7th December 2023

**STATE SIGNIFICANT DEVELOPMENT APPLICATION SSD - 8950984
BURRENDONG WIND FARM – PROPOSED WIND FARM WITH UP TO 70
WIND TURBINES AND ASSOCIATED INFRASTRUCTURE**

Figure 1-1: Regional context

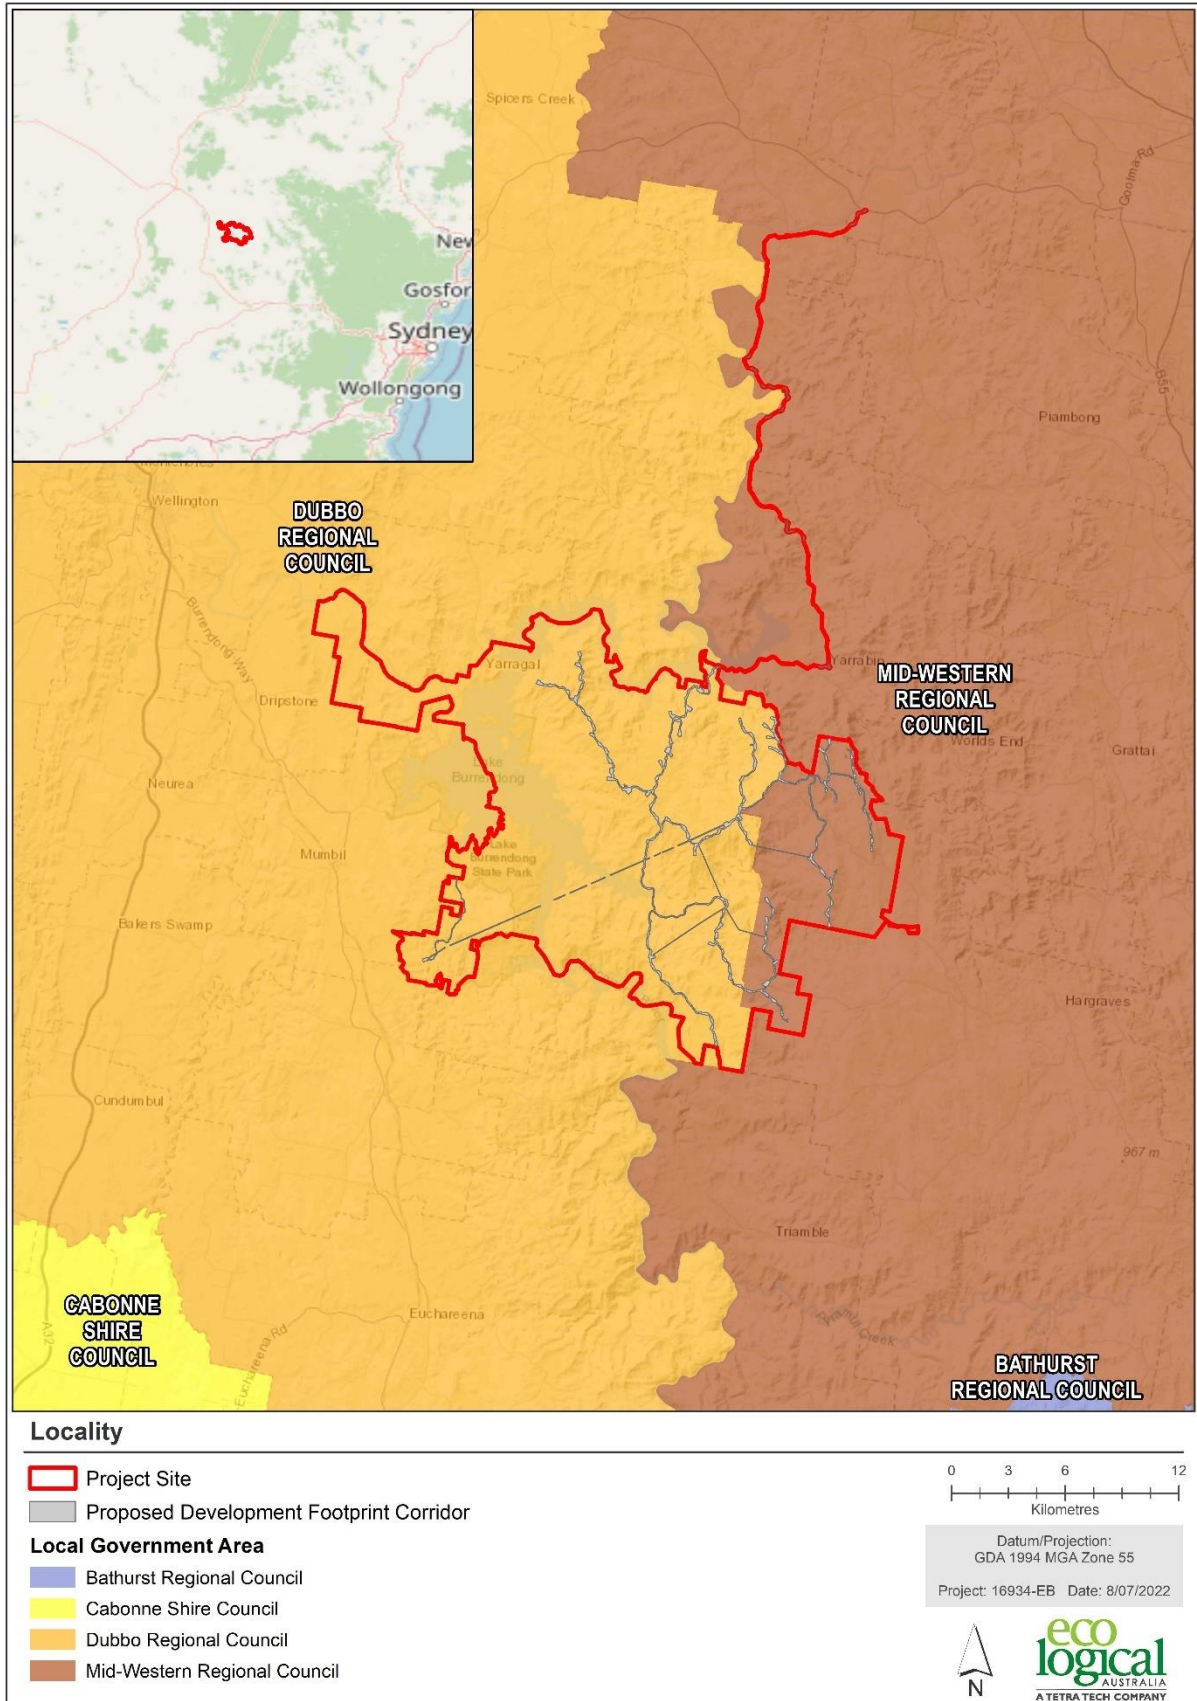
- Figure 1-1 Regional Context of the Project Site.
- According to this figure all transport will be going into the site and out of the site via the north access towards Gulgong. If this is the case how will the project stop staff and subcontractors from using the road to Mudgee?

Figure 6-1: Visual magnitude analysis (Moir 2022)

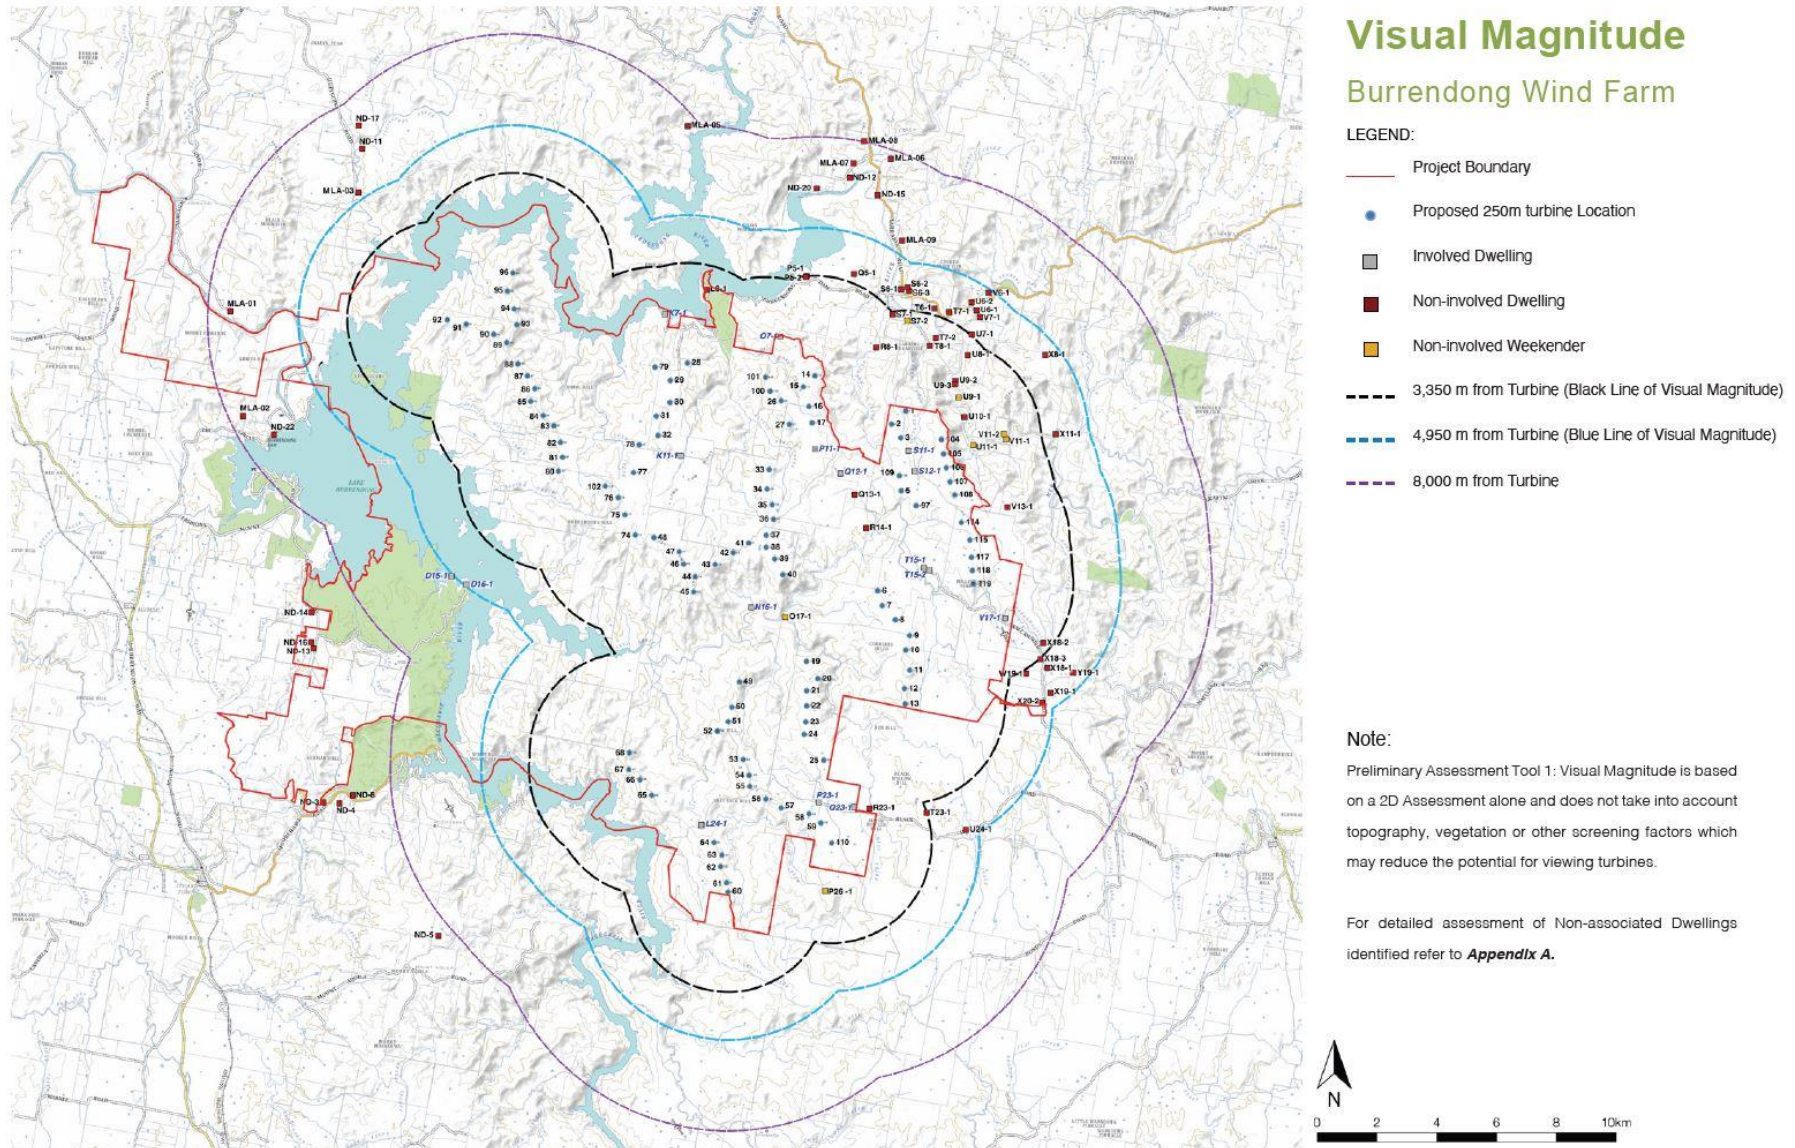
- Landscape 7 Visual. Identified 20 non-associated dwellings within 4950m of the nearest WTG.
- This number is so WRONG. These 20 non-associated dwellings are NOT even 50% of the dwellings that are in the areas. This section will need to be re done with the correct number of non-associated dwellings included. Arc Energy, Eco logical and Korea Zinc are so misrepresenting this area that the entire EIS should be discarded and the EIS must be undertaken again. No legitimate accuracy can be taken from this section of the report. I know for a fact that one particular property that will have a front row seat to over 20 WTG has never been approached. They are within 3000m from the WTG.
